# Responses to Comments

VICINITY MAP
(NOT TO SCALE)

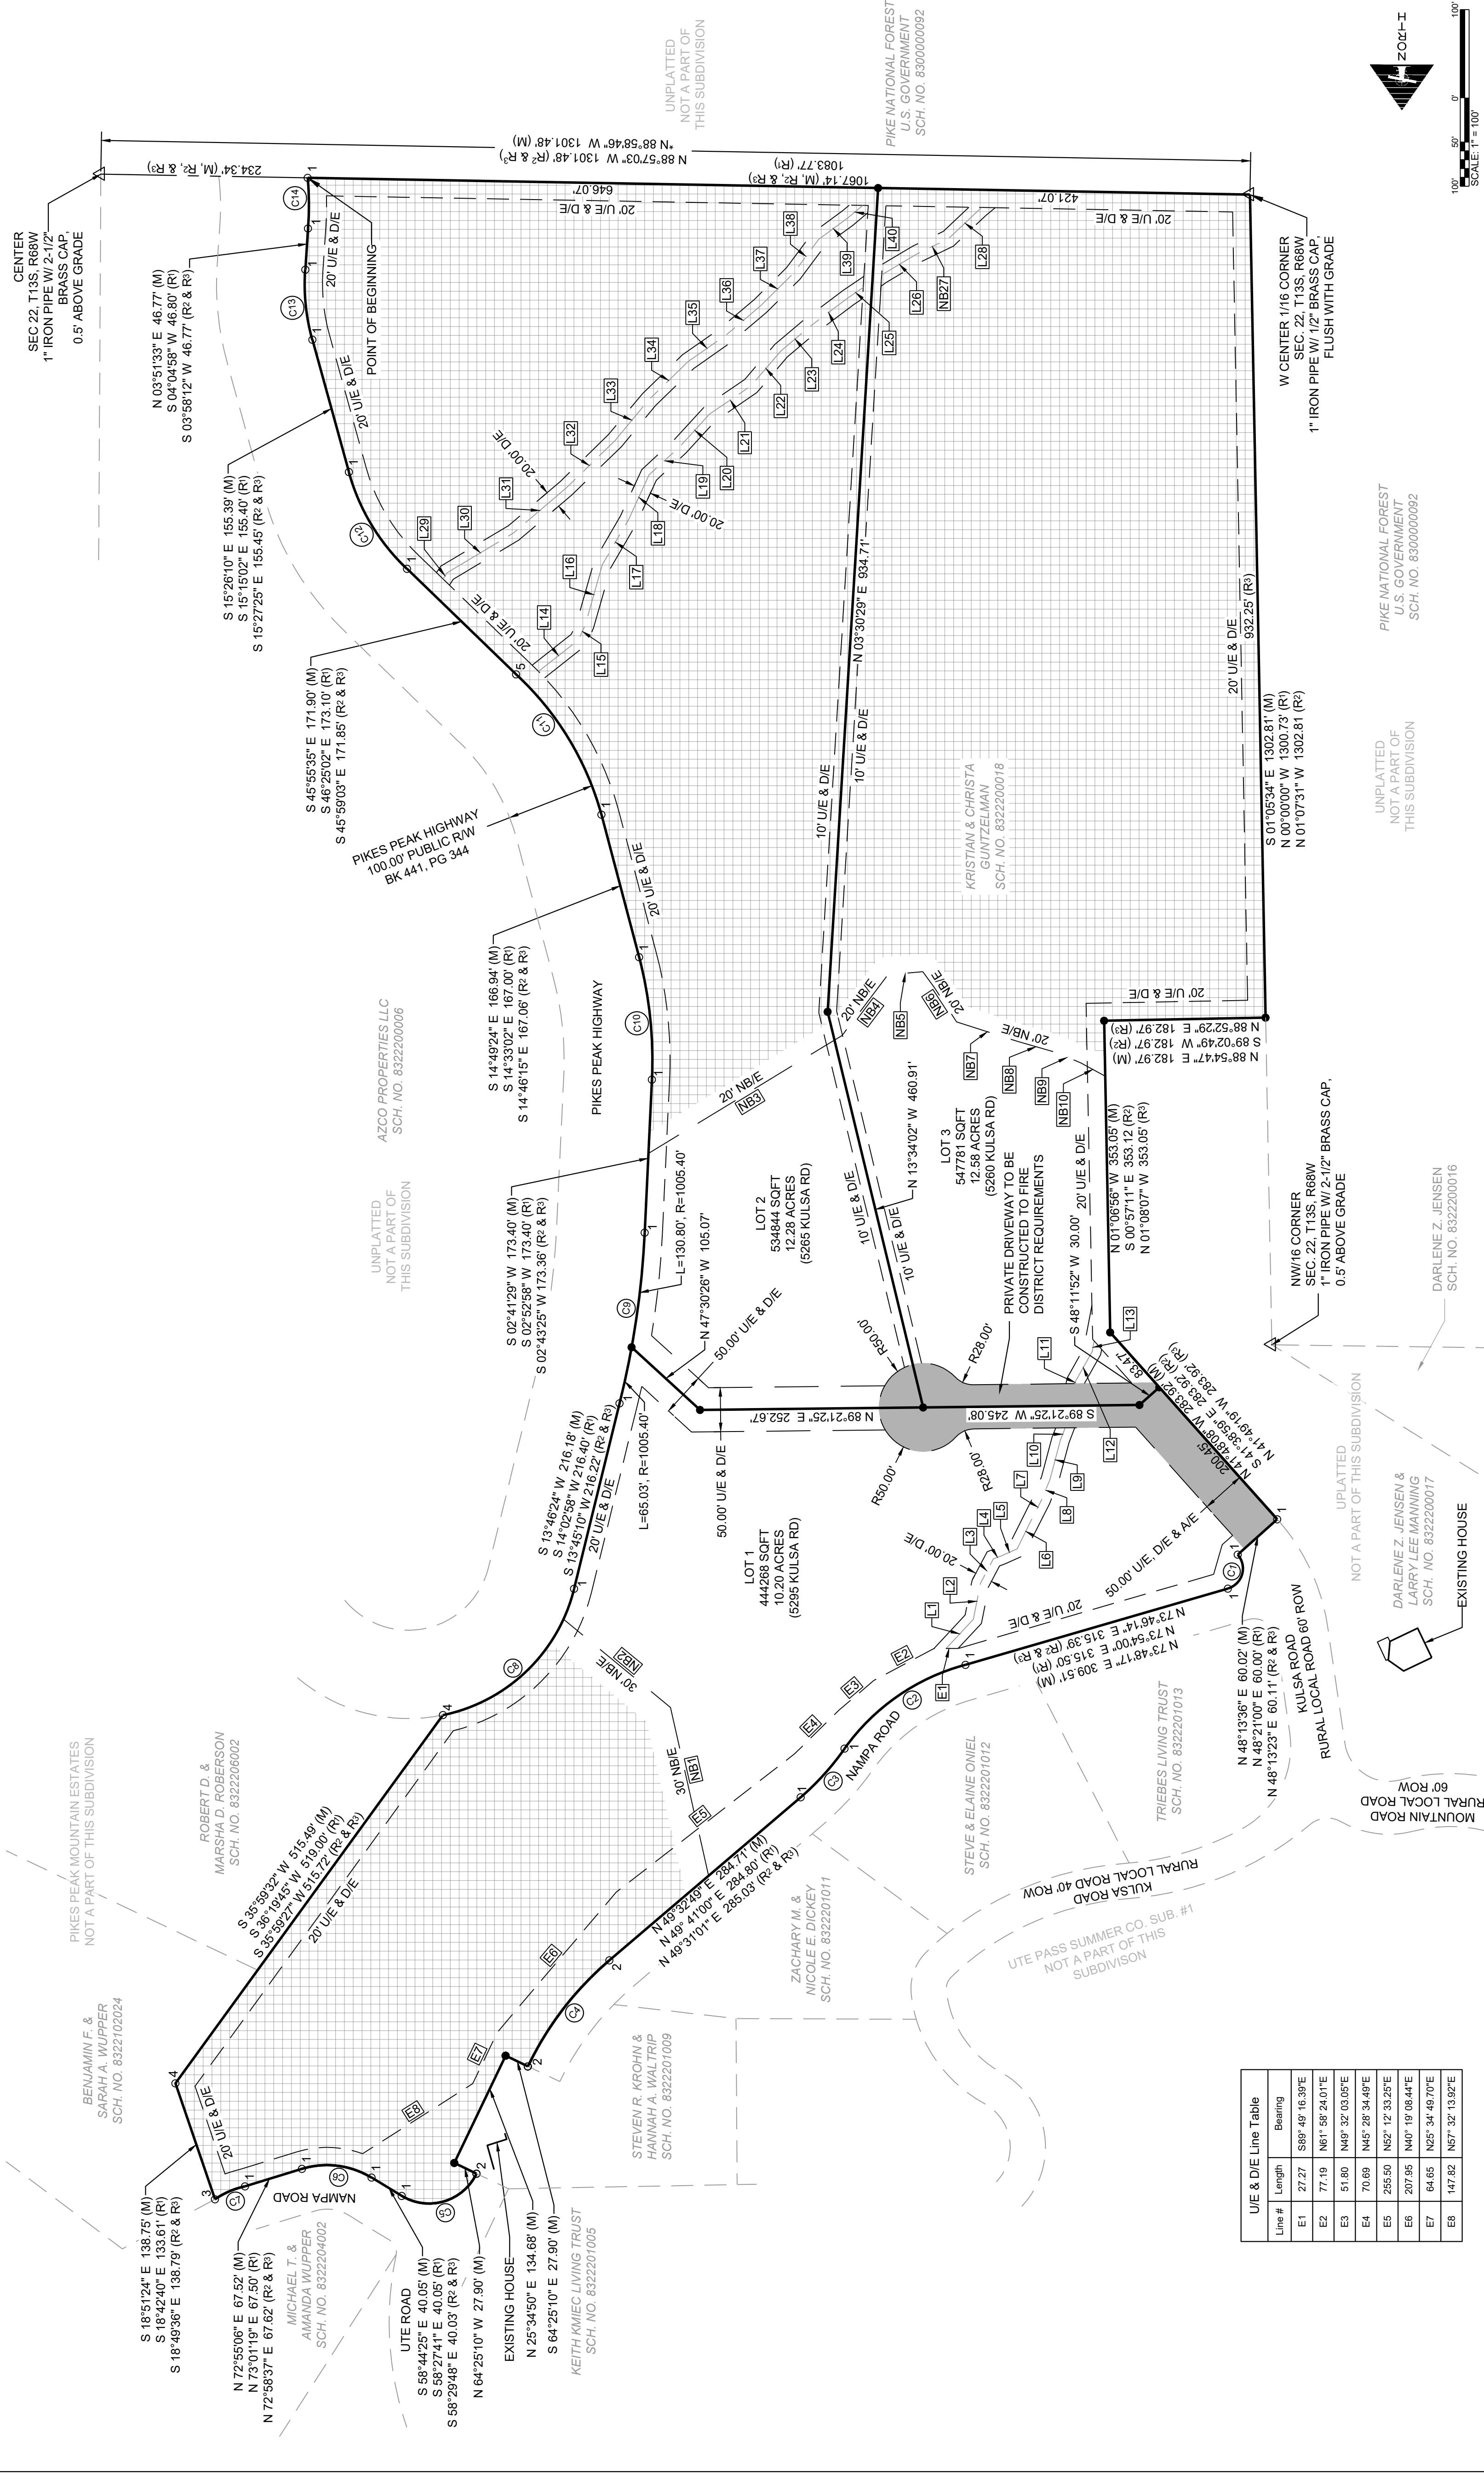
- **Colorado Springs Utilities Dev. Svc.:**
  - Please show easement recorded at B3113 P392. **Easement is unplottable. During discussions with Gary – CSU Advanced Geomatics, Gary indicated the easement would be unenforceable and to just add a note to the plat that the easement is unplottable, but may impact the property.**

- Please label these as Public Utility Easements throughout the plat. **U/E designation further identified in the legend as “Public Utility Easement”.**

- Missing monument symbol. **Monument added.**

- Missing monument symbol. **Monument added.**
- Missing monument symbol. **Monument added.**
- Please include the CSU Terms and Conditions statement regarding 212112548 either in the notes or under the Easement section. **Reference added under Easements section on first page of plat.**

- **County Attorney – Development Review: Comments and edits to Access Agreement attached.**
  - The common driveway is not identified as a Private Access and Utility Easement on the plat. Please identify it as such on the plat. **Private driveway easement label updated on plat to access easement (A/E).**

- **Final Plat:**
    - At a minimum, place “natural” drainageways which convey flows greater than 15 cfs in a drainage easement. **Easements added.**

- Per comment on the drainage report, show the drainage easements on the plat. **Easements added.**
    - Please add in the no-build designation for the areas with geologic hazards/steep slopes. Anything over a 30% grade shall be a no-build due to steep slope. **No-build areas identified on the plat.**

- Show the “No Build/Slope Easements” at the toe or crest as noted in Fig. 5 of the Geotech report. **Easements added to plat.**
    - Show as well the building setback line that is 20 feet from the toe or 30 feet from the crest. **Setbacks added.**

- Please add “Rural Local Road 40’ ROW” underneath Kulsa Road. **Added.**
    - Please put “Rural Local Road 60’ ROW” underneath label. **Added.**

- What are these? Where are the drainage and bridge fee lines? **Fee lines updated. No drainage or bridge fees required as Upper Fountain Drainage Basin is an unstudied basin within El Paso County.**

POST-DEVELOPMENT DESIGN POINT SUMMARY TABLE

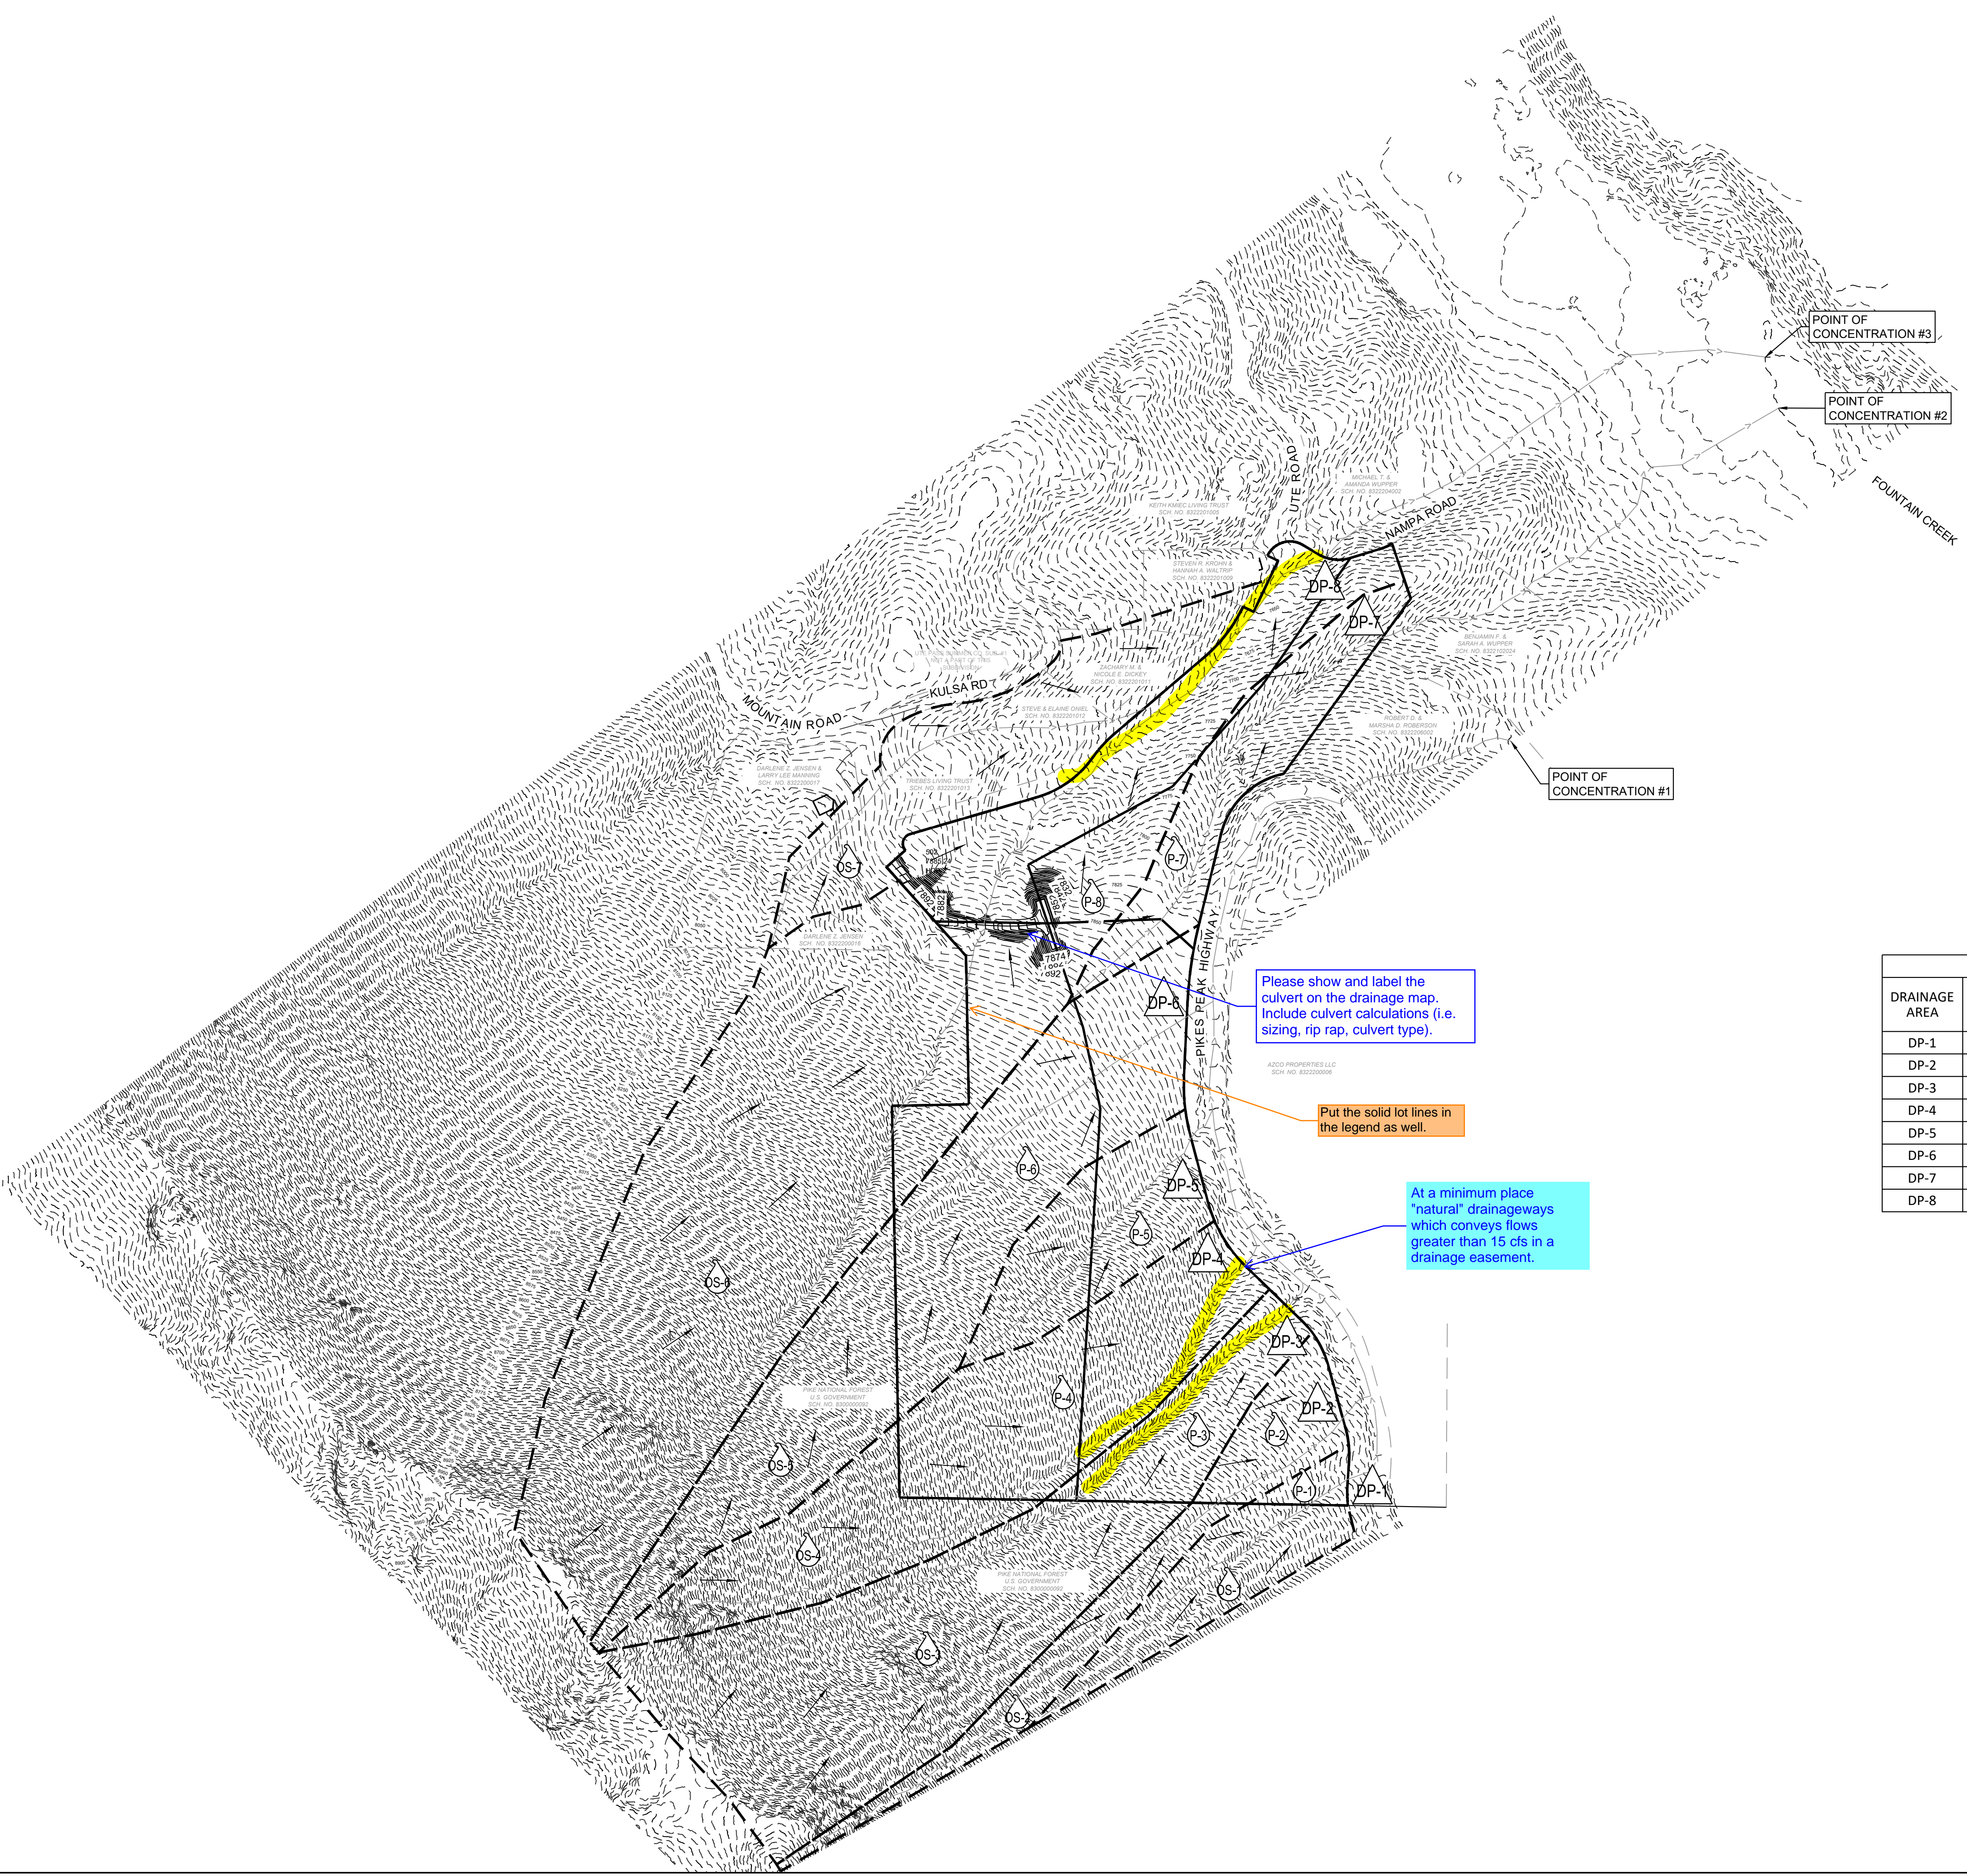
- **Revise the time of concentration lines and values for basins 1, 2, and 3 for both pre-development and post-development conditions.**
  - **Time of concentration lines should be drawn to the drainage basin outlet. Additionally, the proposed ditches will change the contours and will change the time of concentration lines and values for the impacted basins. Time of concentration lines are drawn to the basin outlet. Not sure what this comment is referring to? There are no proposed ditches. The proposed 3-lot residential subdivision will be served by a private driveway. The private driveway is to be constructed by the future lot owners. They are responsible for providing an engineered site plan at time of building permit application showing the house location, driveway location, and any culverts that might be required based on the location of these items. Developer is not constructing the future homes. Only creating the lots, so it is unknown at this time where the houses or driveways will be located. Noted has been added to the plat.**

- **Update pre- and post-development peak flow rates accordingly. Revised for the new 3-lot subdivision.**
- **Verify that the proposed subdivision will not result in increased runoff to Fountain Creek and make design changes as necessary to minimize those impacts. There will be a very minimal increase in runoff from the proposed development. With the route runoff will take leaving the proposed development, runoff will be allowed to infiltrate into the soil. There will be no negative impact to Fountain Creek due to the negligible increase in runoff from the proposed development.**

- **Provide plans for the proposed roadside ditches and show proposed contours on the post-development drainage map. There are no proposed ditches. Development is now a 3-lot minor subdivision. Private driveways are to be constructed by the future lot owners. They must submit an engineered site plan at time of building permit. The developer is not constructing any of the future homes. Only creating the lots. A note has been added to the plat.**
